**Re: Application by AQUIND Limited for an Order Granting Development Consent for the AQUIND Interconnector Project**

**Ref: EN020022**

I write in response to your letter to our client Sainsbury's Supermarkets Limited ('**SSL**') on 15<sup>th</sup> September 2020 in respect of the above Development Consent Order ('**DCO**'). The purpose of this letter is to submit our written representation on the relevant matters of the DCO which directly impact upon SSL and their property, Sainsbury's Supermarket, Fitzherbert Road, Portsmouth, PO6 1RR ('**Sainsbury's Farlington**') which SSL hold the freehold interest.

TITLE: **Order Limits including Onshore Cable Corridor Section 4d**
Sheet 7 of 15

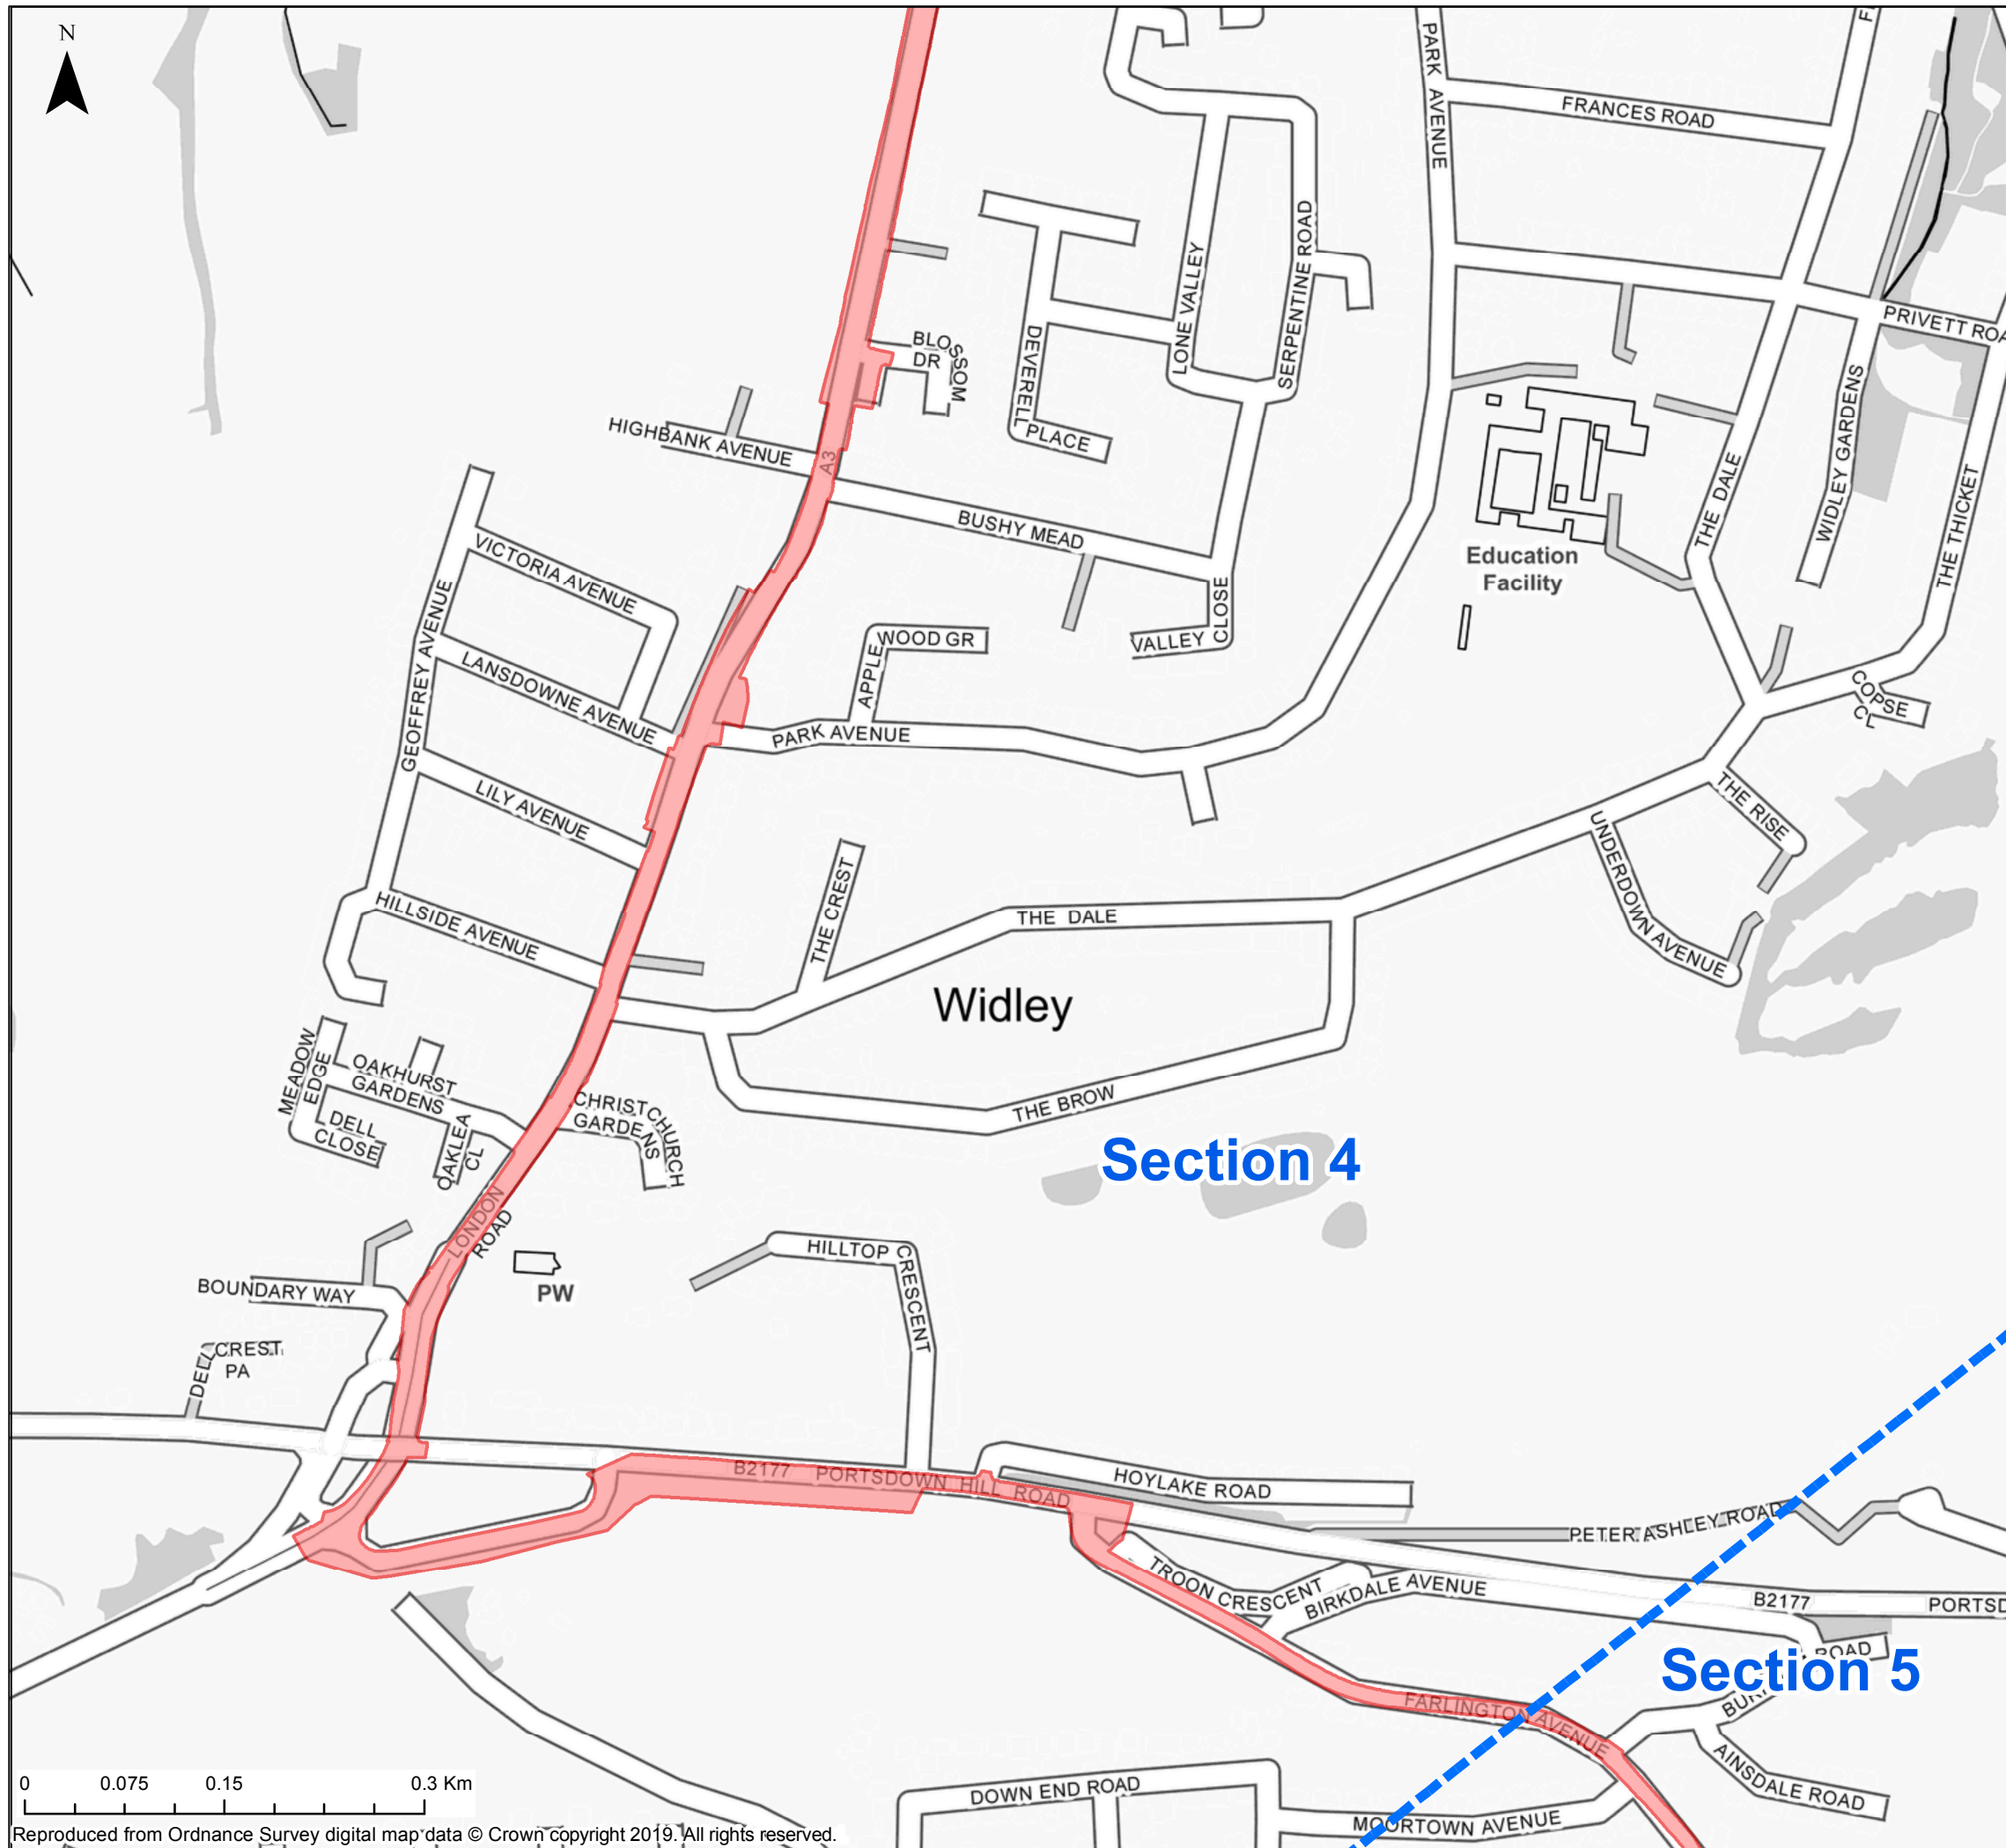
The proposed path of the cabling route across the western boundary of Sainsbury's Farlington car park is shown in detail on Sheet 7 of the Land Plans. It is intended for the cabling route to deviate from the highway and instead run parallel to the A2030 Eastern Road through the full length of the Sainsbury's Farlington car park before exiting at the southern boundary with the West Coastway Railway Line. As such, this section of the cabling route requires the largest acquisition of rights over private land within the DCO and we consider the exploration of alternatives to avoid disruption a necessary requirement.

The Order Limit allows for the acquisition of rights over land on a significant part of the car park and circulation routes relating to the Sainsbury's Farlington store. In total, 12,279 sq. m. of land is subject to new rights being acquired which is illustrated in an extract from the Land Plans below:

The Order Limit encompasses the entire access route into the store presenting a significant level of risk for disruption to the operation of the store during the works period. Furthermore, the car wash to the south of the access road and an area of scrub land to the north-east have been included without having a clear practical use for the works.

This section of the Order Limit is of primary concern not least because of the potential impact to traffic flow caused by the blocking of the circulation road during the works period, but also the width of the Order Limit which encompasses several rows of car parking spaces. It is not acceptable to our client for the Order Limit to be so wide at this point whilst the cabling route itself we be less than 10m in width.

The area covered by the Order Limit at the southern portion of the car park extends beyond the necessary land requirements for the cabling works and HDD compound. The proposals include a significant amount of car parking to the east of the proposed location of the HDD compound with no obvious use as part of the scheme.

The clear and obvious alternative to the current proposal is for the entirety of the cabling route in this location to fall within the A2030 Eastern Road. If this is not possible, then the route should pass through as little of SSL's land as possible. Crucially, this should avoid the access road to the store at Fitzherbert Road and mitigate to a greater extent the disruption caused to the operation of the store. The proposed cabling route will severely limit the traffic flow into and out of the store car park, will prevent access to the petrol filling station and car wash. The loss of the car parking spaces as a result of the works would negatively impact on trading performance resulting in significant losses.
